**LOWER EDGE FARM
TINKLERS LANE
SLAIDBURN
LANCS
BB7 4TP**

320070866P

Re Land at Brockthorne Farm Tosside Road, Tosside

Location Plan

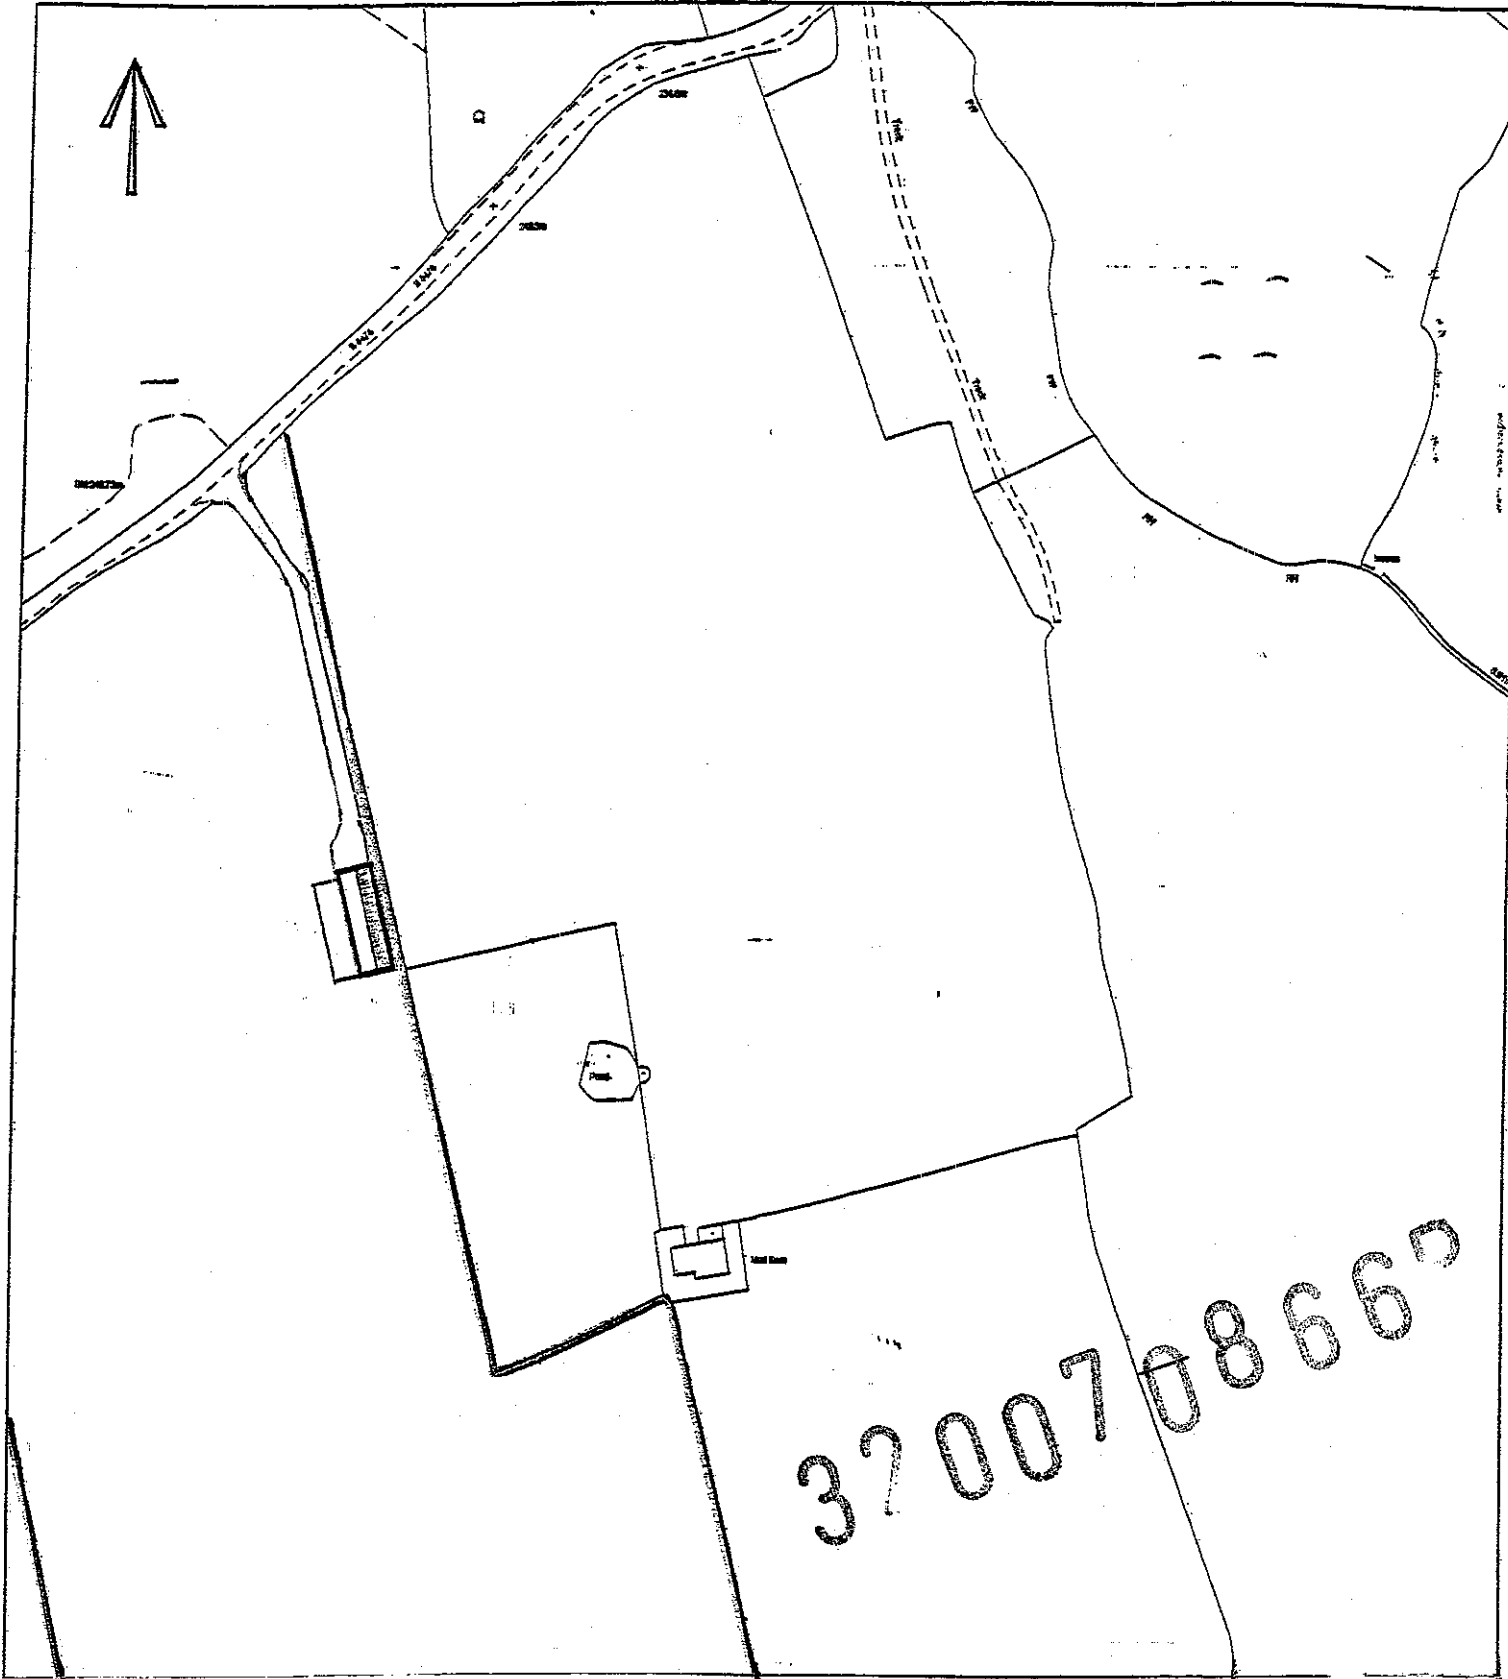
1. I agree that the building can be sited 10 m nearer to the road, and I attach an amended site plan
2. I confirm that the North & West elevations will be constructed of block and faced with 6-8 inches of facing in local stone.
